THE ABLE MARINE ENERGY PARK DEVELOPMENT CONSENT ORDER 2012  
(PINS REFERENCE NUMBER: TR030001)

COMMENTS ON THE APPLICANT'S RESPONSES TO RELEVANT REPRESENTATIONS  
(INCLUDING COMMENTS ON THE SUPPLEMENTARY INFORMATION SUBMITTED BY  
THE APPLICANT AS PART OF THEIR RESPONSE)

ON BEHALF OF  
E.ON UK PLC  
(UNIQUE REFERENCE NUMBER: [REDACTED])

2 August 2012

Figure 29 Longer term potential morphological response along intake-outfall line (E.ON)

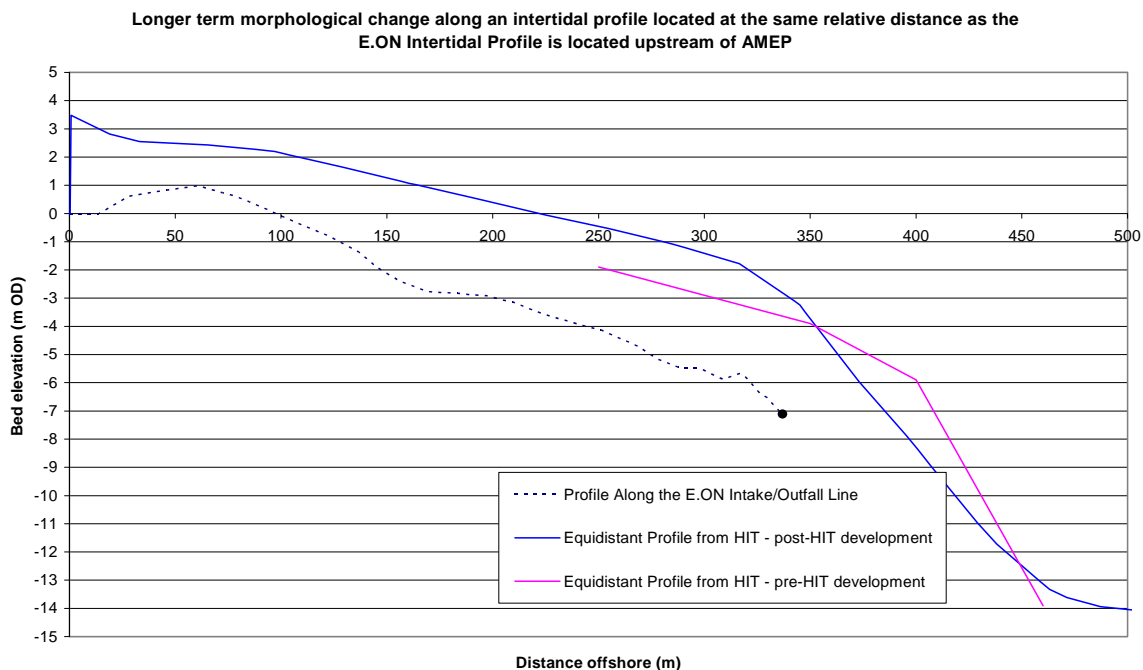
- 2.14 The implication of this is that eventually the current E.ON outfall may be above the water line for at least part of the tide. Clearly this is not acceptable.

- 2.15 The applicant's report "Update to longer term morphological predictions in the region of the Centrica and E.ON intakes and outfalls" assessed morphological changes over a much shorter period (30 weeks). This specifically modelled the effect of the AMEP. The model results appear to predict that the E.ON outfall structure will become covered by deposition of sediment and possibly become blocked during periods of Cooling Water system inactivity.
